Internal Ref: EXTERNAL/2024/0020

Inner West Council Response: SSD-76927247 – The Timberyards by RTL Co.

Property: Lots bound by Victoria Road, Sydenham Road, Farr Street and Mitchell Street, Marrickville NSW 2204

Proposed Design

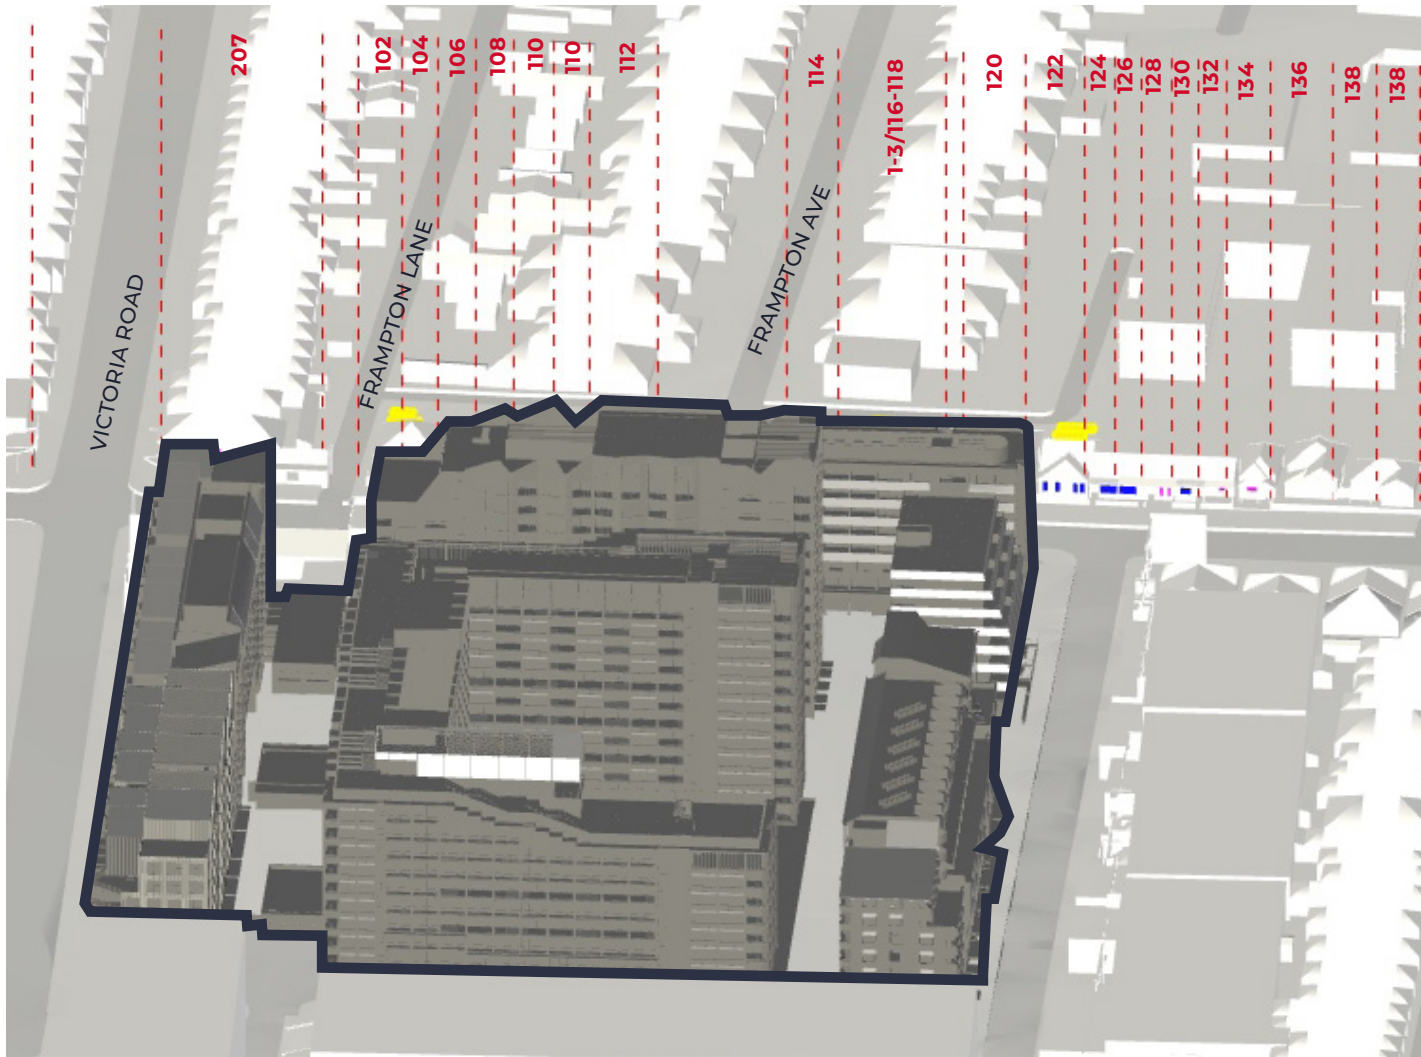
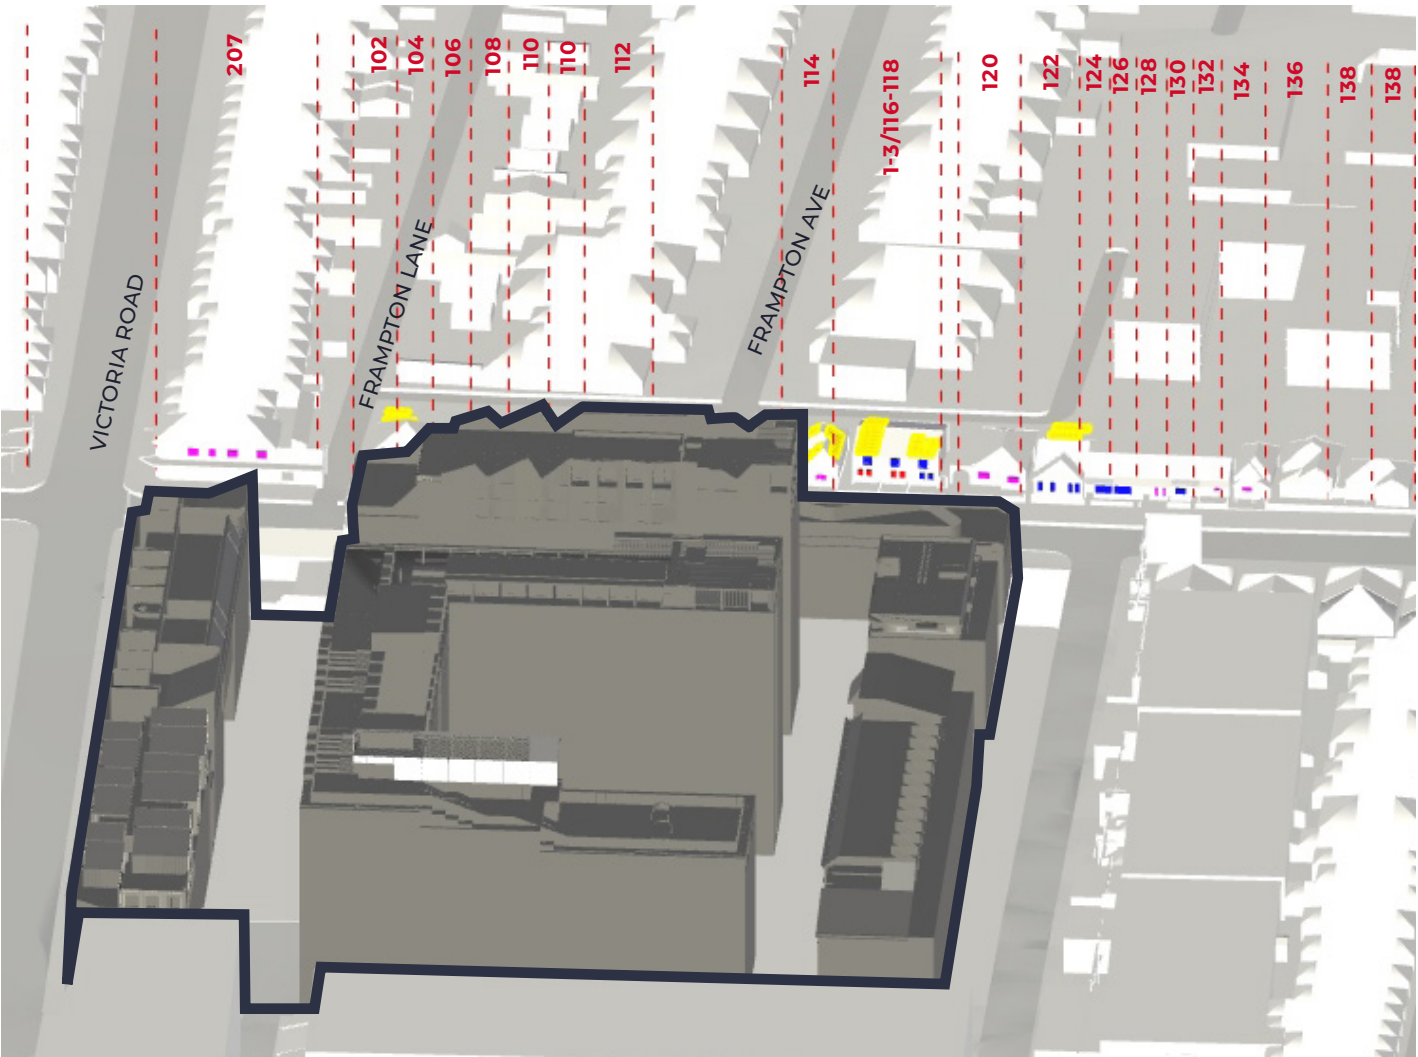
- c) The supplied sun eye diagrams (DA-795-101) and solar access diagrams are of a low-quality and faded and are not sufficient to conduct a comprehensive solar impact assessment most notably to the Corner Site. They should highlight which units are being counted as receiving the required 2 hours.
